MDT-PUDSP22007-R1-Soils & Geology Report redlines.pdf Markup Summary

ADD AREAS OF GROUNDWATER BELOW SURFACE IS MITIGATION CRAWLSPACE NLY N BSEMENT AS STATED IN loi

DEVELOPMENT PLAN
STERLING RANCH EAST
PRELIMINARY PLAN NO. 2
COLORADO SPRINGS, CO.
FOR: CLASSIC SRJ

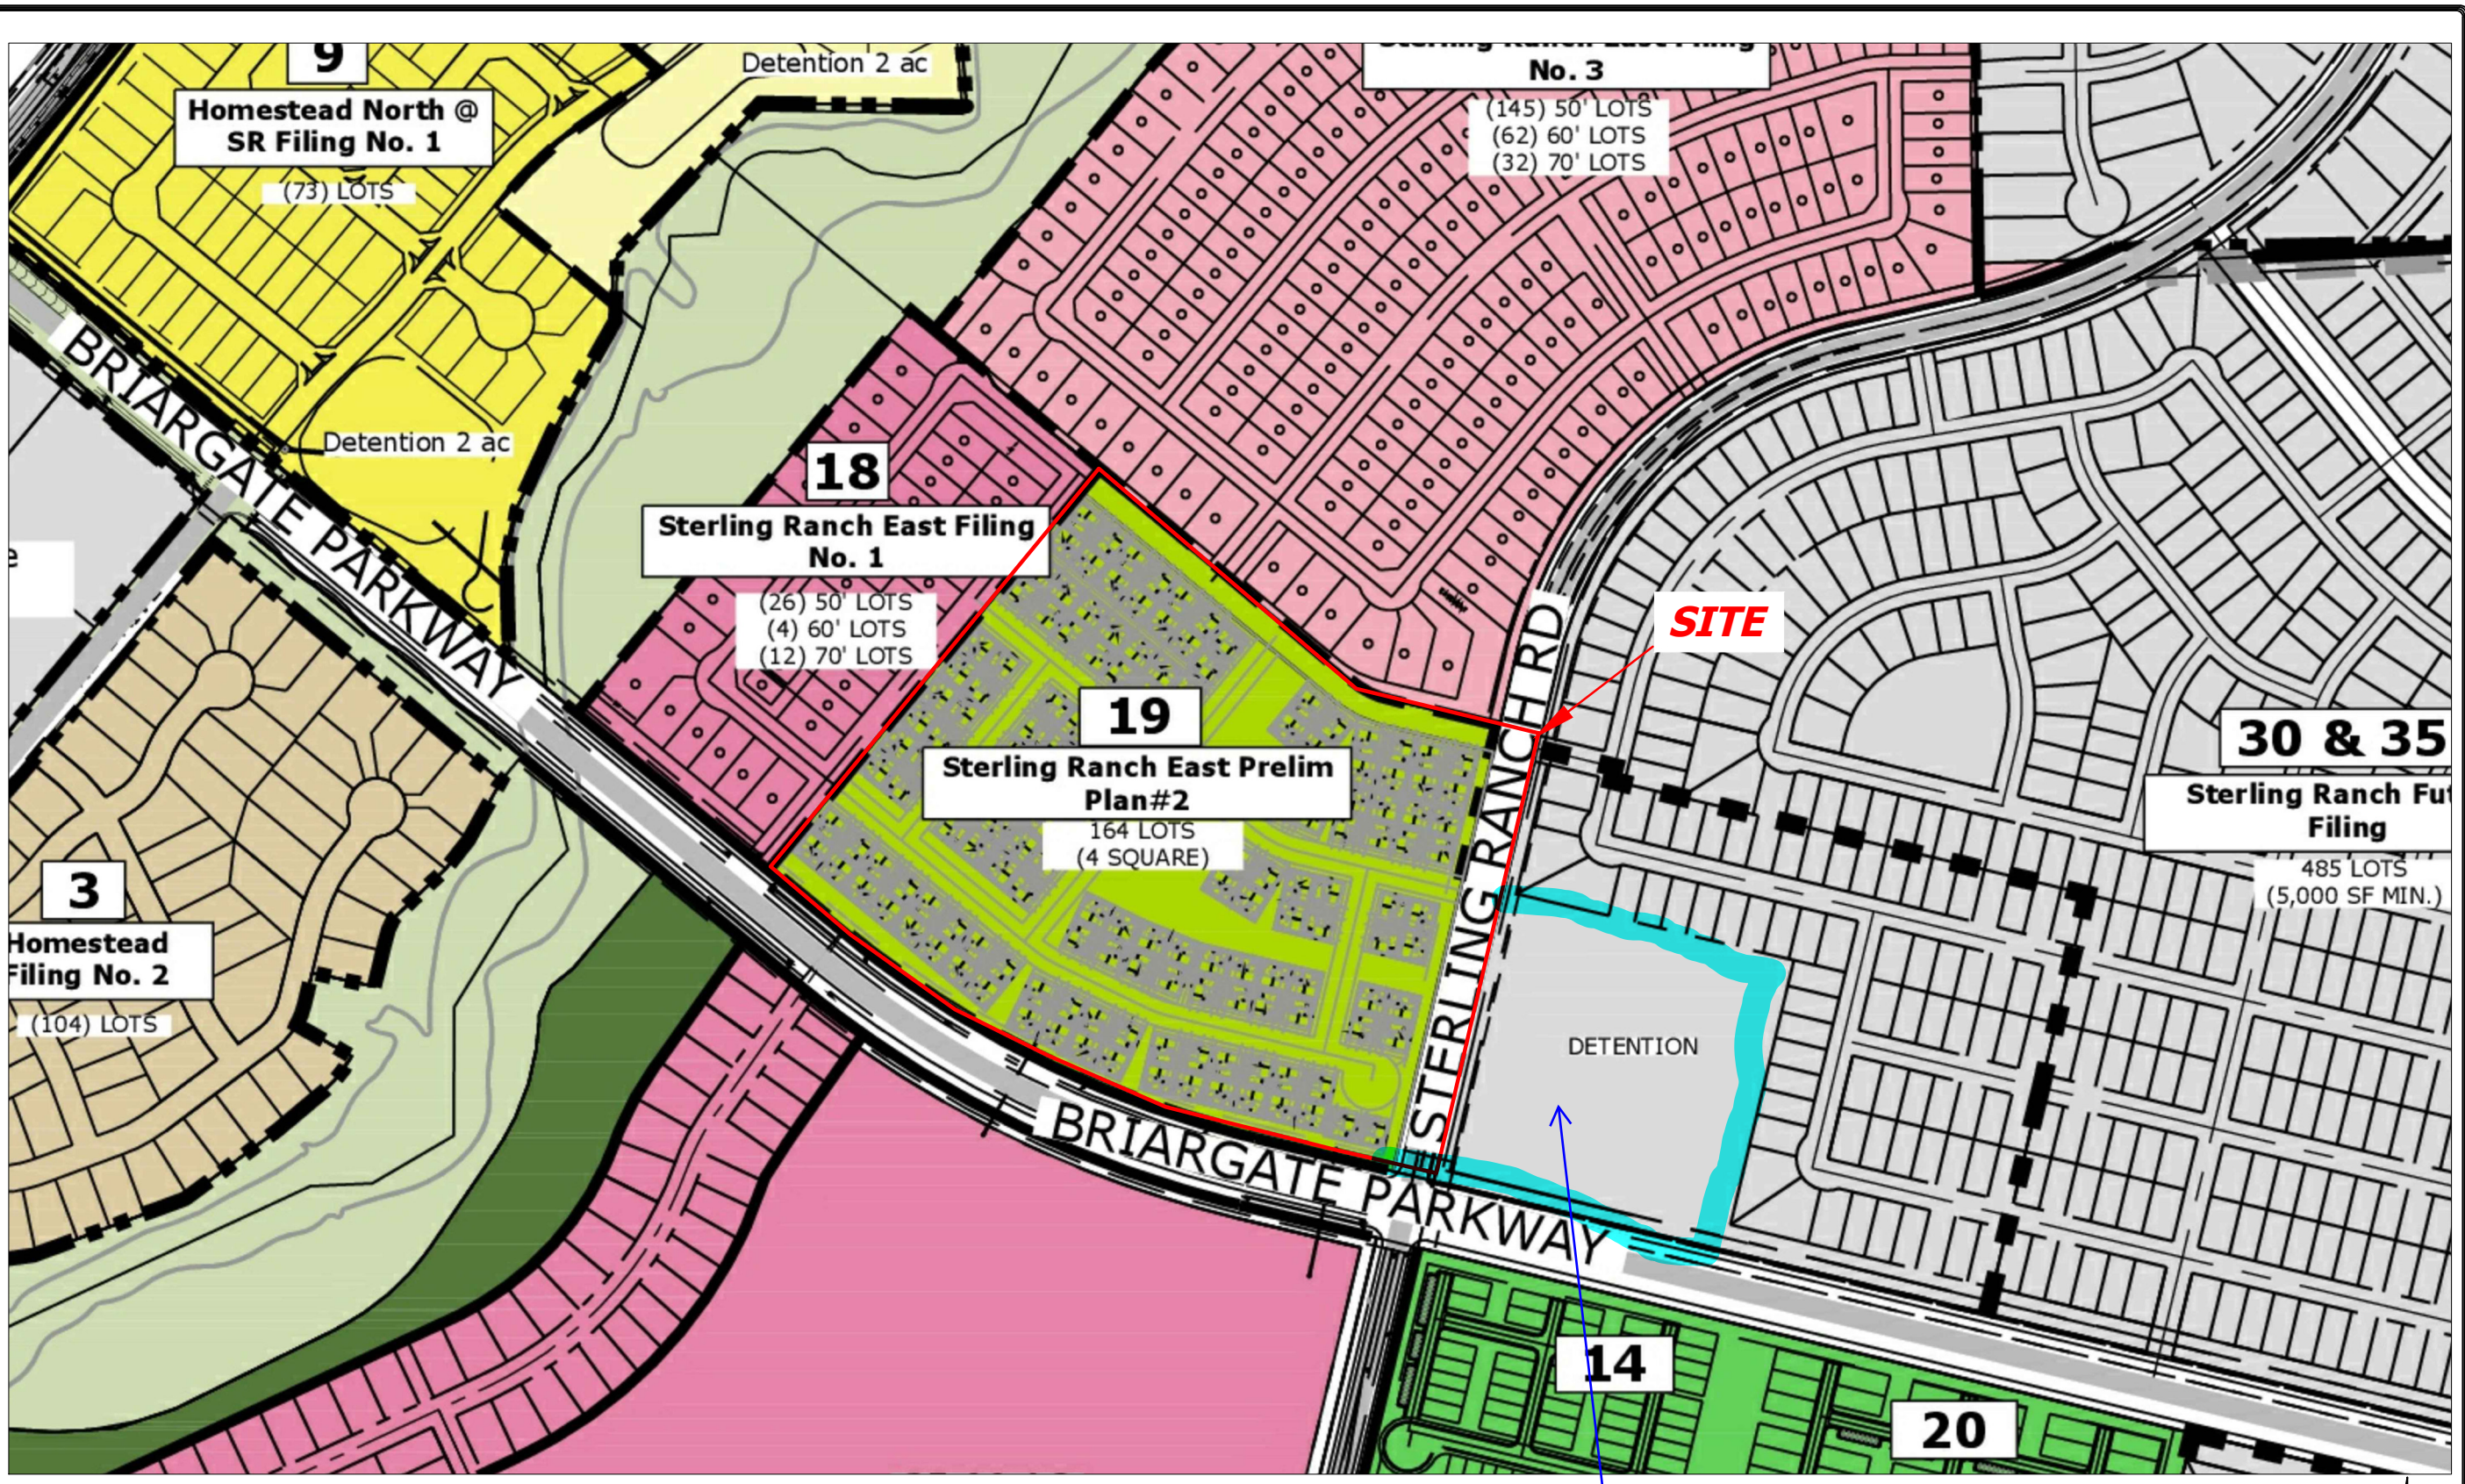
Includes this area

It appears that proposed cut for pond is up to 24 feet, plus depth for a micropool - address how groundwater is to be handled.

SITE PLAN/TEST BORING LOCATION MAP
 STERLING RANCH EAST
 PRELIMINARY PLAN NO. 2
 COLORADO SPRINGS, CO.
 FOR: CLASSIC SRJ

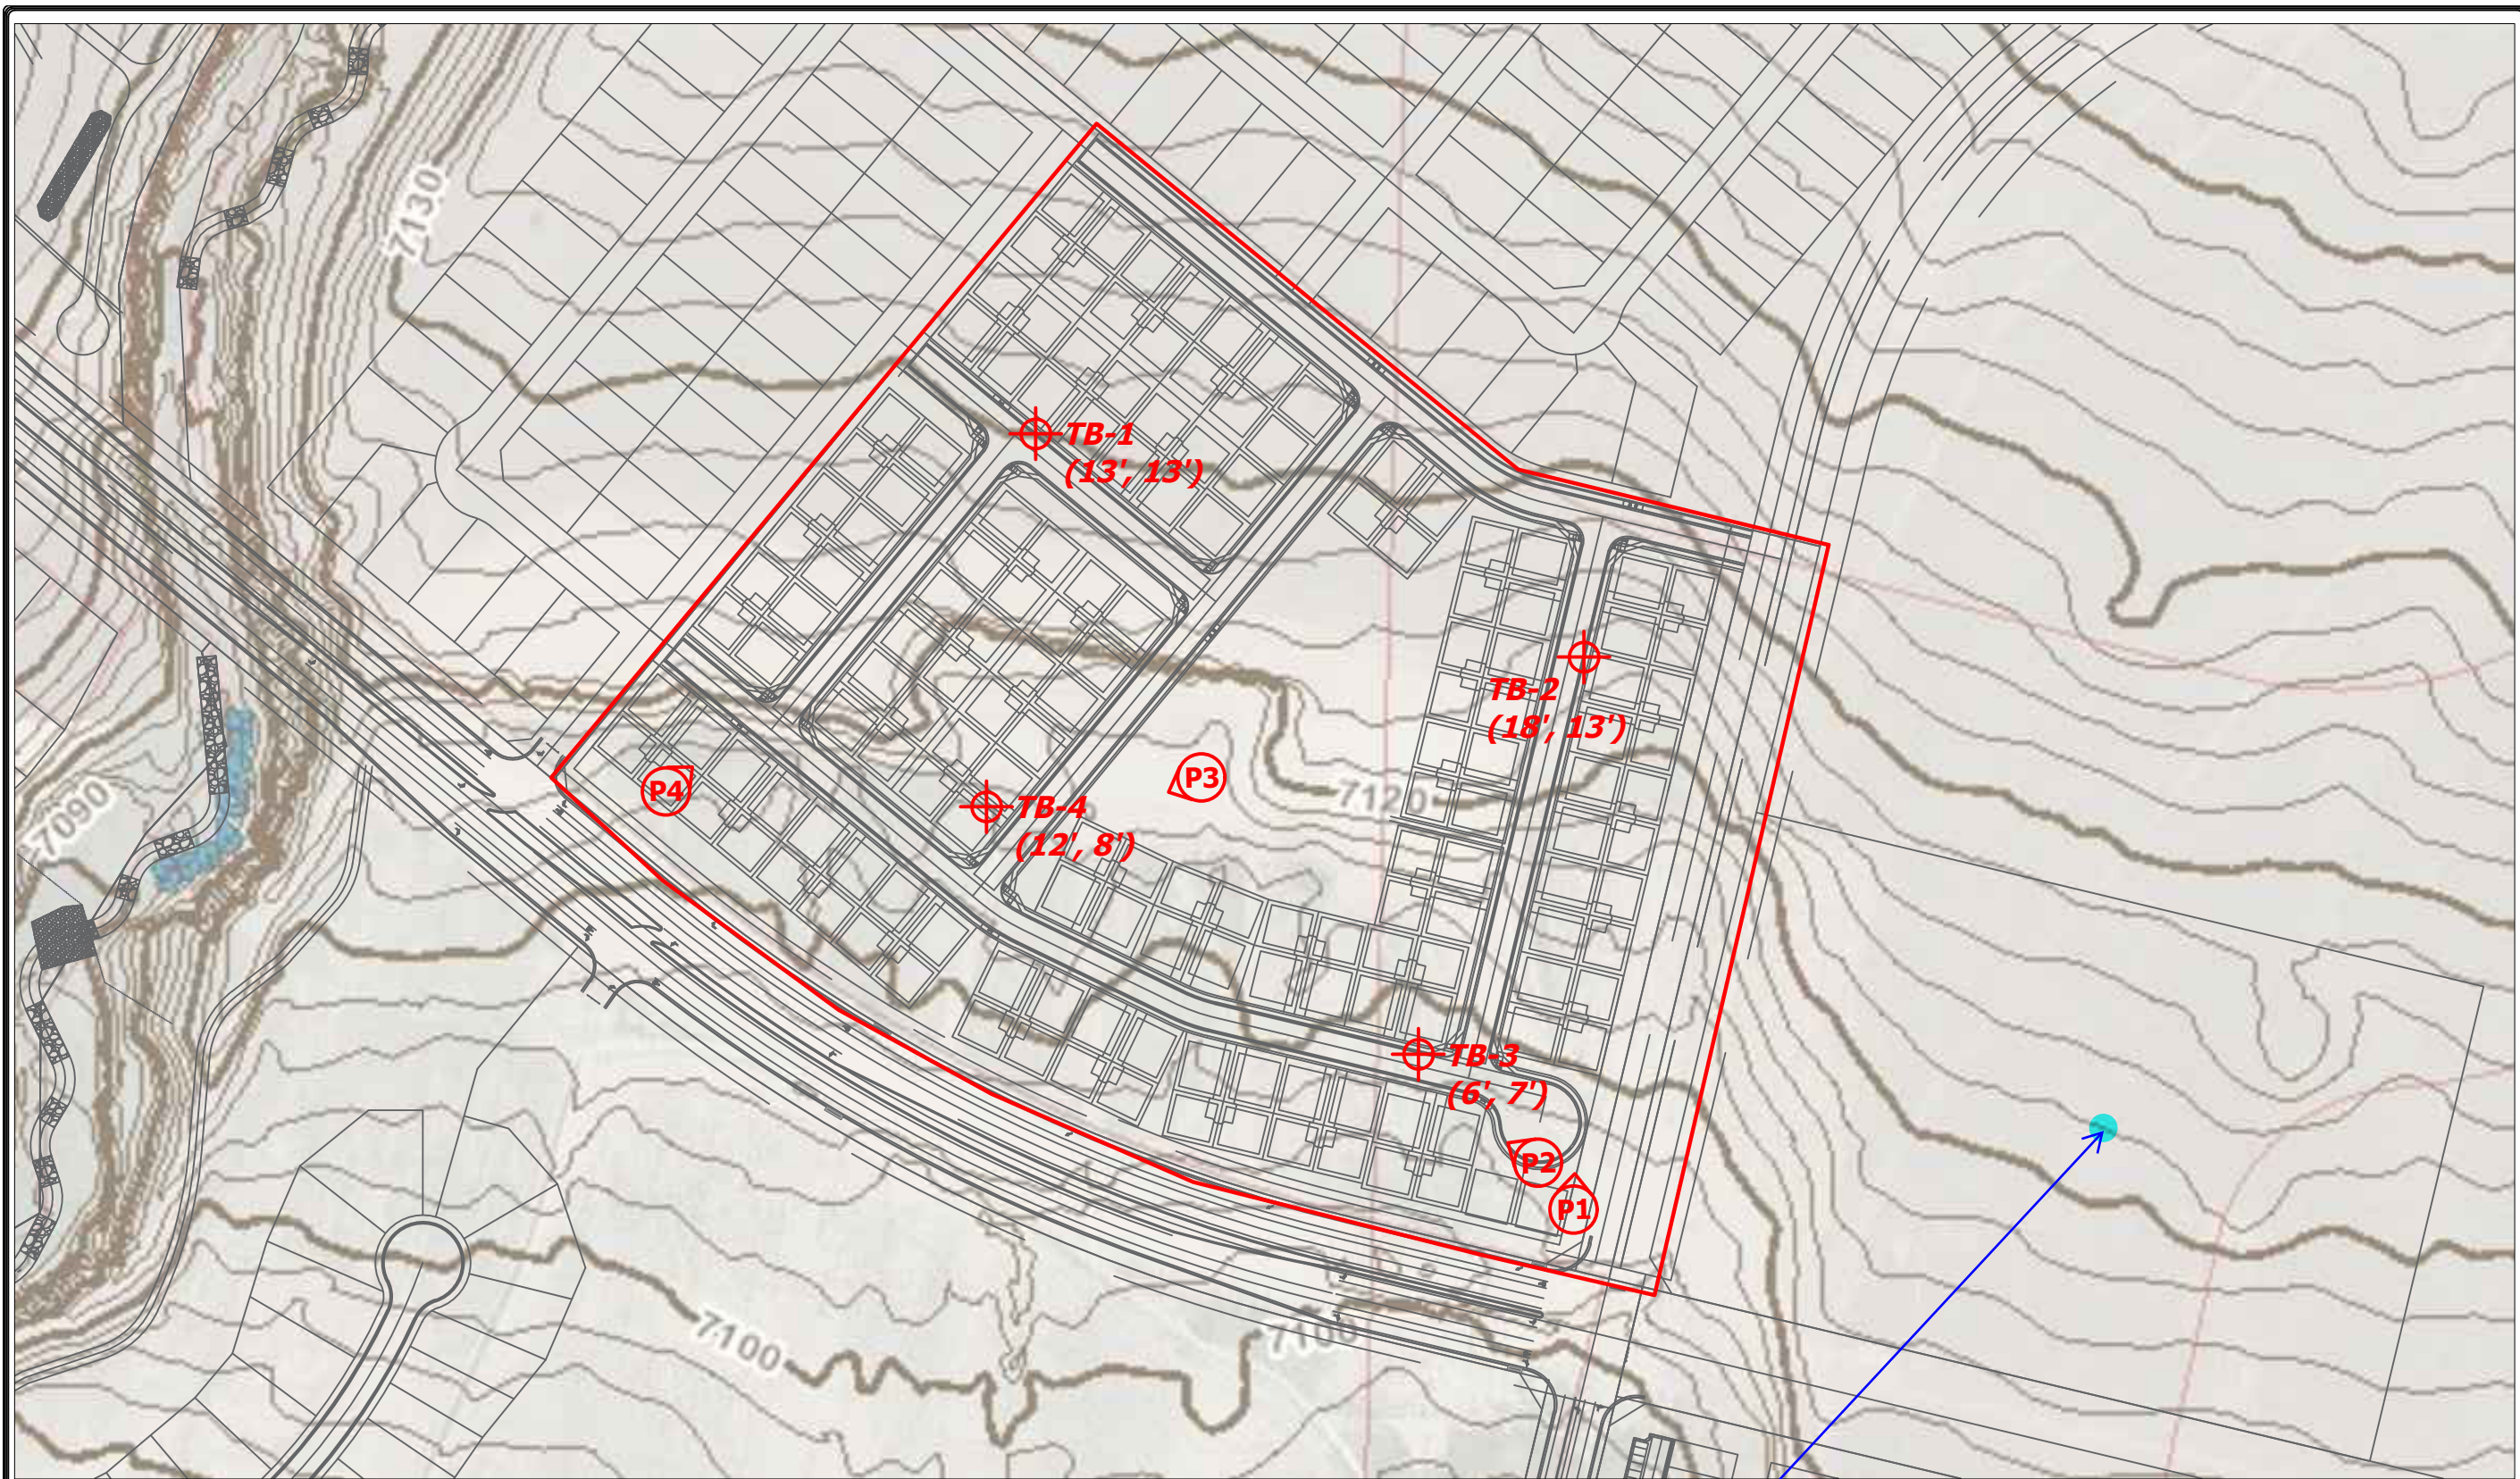
add a boring
